Sydney Modern Project
State Significant Development
DA SSD 6471 3/11/17

Development Application and Environmental Impact Statement

Grounds of Objection

Public Viewpoint 15: Image A - Existing view

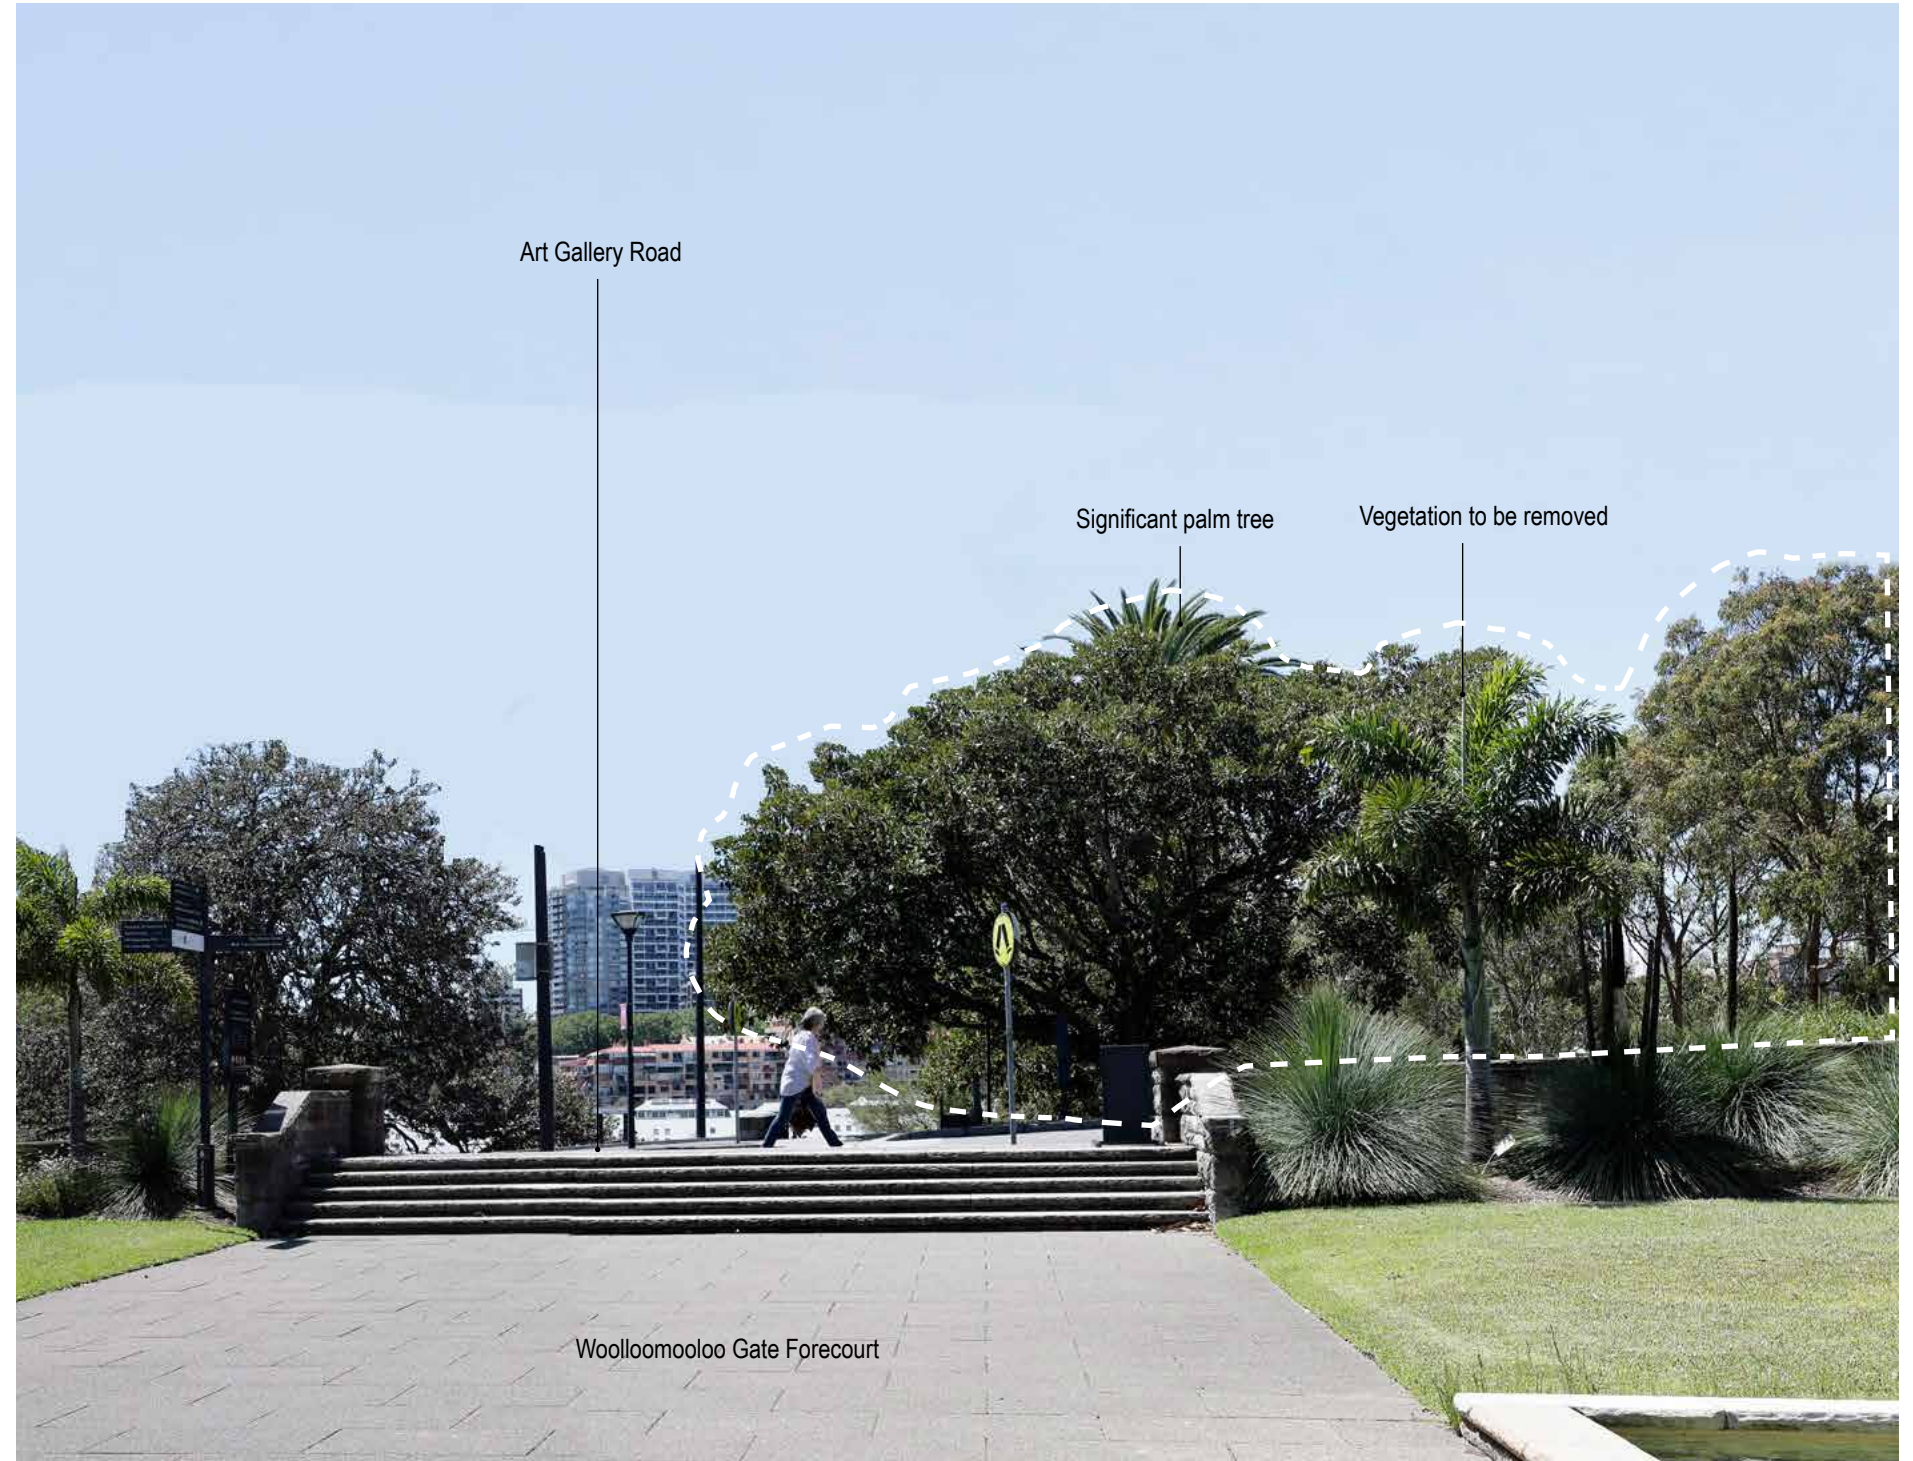
- The largest quantity of removed mature vegetation is proposed opposite Woolloomooloo Gate, running from Art Gallery Road to the edge of the Navy fuel bunker area. Views to Potts Point will be restricted by the new built form looking east from Art Gallery Road in particular. Appendix H
- When exiting the gardens at Woolloomooloo Gate the view will mostly be of roofline because of the descending slope of the land.
